Application No: FP/70/21/PL  
Site Address: Kenwood Court 6 The Midway Felpham PO22 7EZ  
Description of works: Erection of a car port and rearrangement of existing parking spaces. This application is in CIL Zone 4 (Zero Rated) as other development.

Thank you for your internet representation made on 19th May 2021 which has been recorded as an objection with the comments as follows:

**PROPOSED CAR PORT
PLANS AND ELEVATIONS**

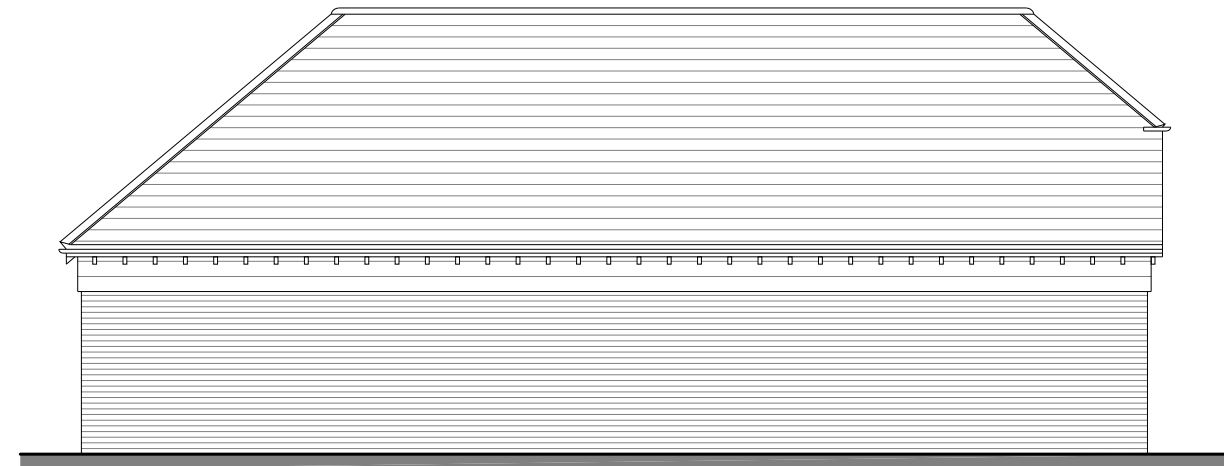
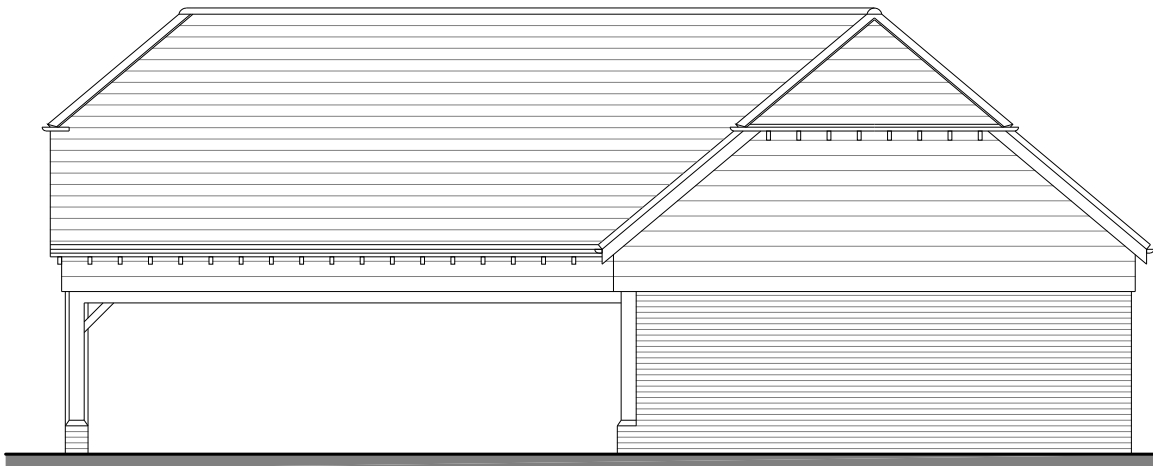
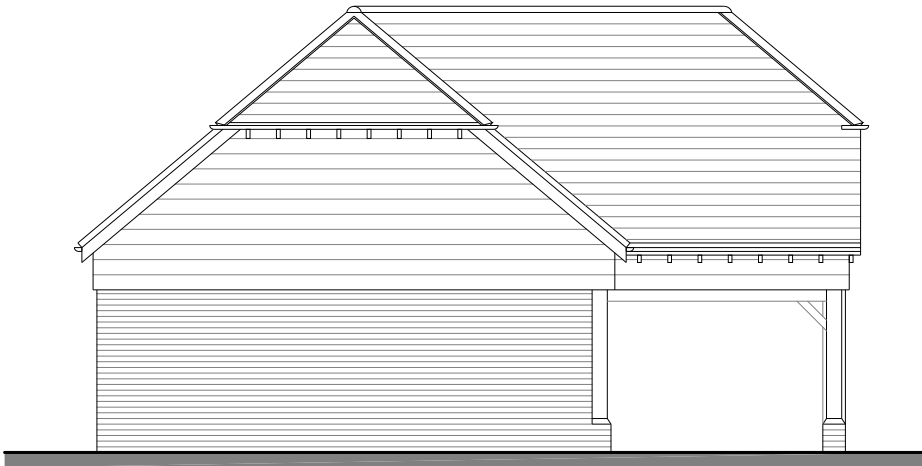
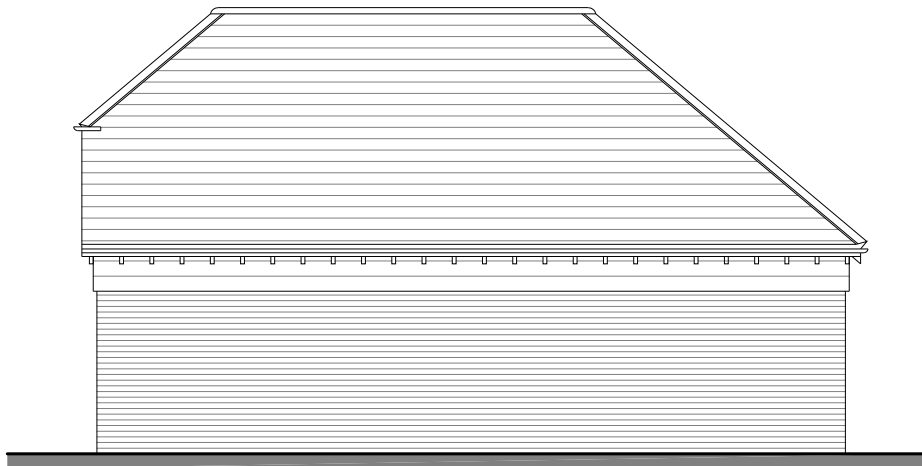
The height of car ports would hinder the views over the back of property. Very Green and lovely views presently. Also nesting birds would be affected. Not clear what is meant by re arrangement of current parking
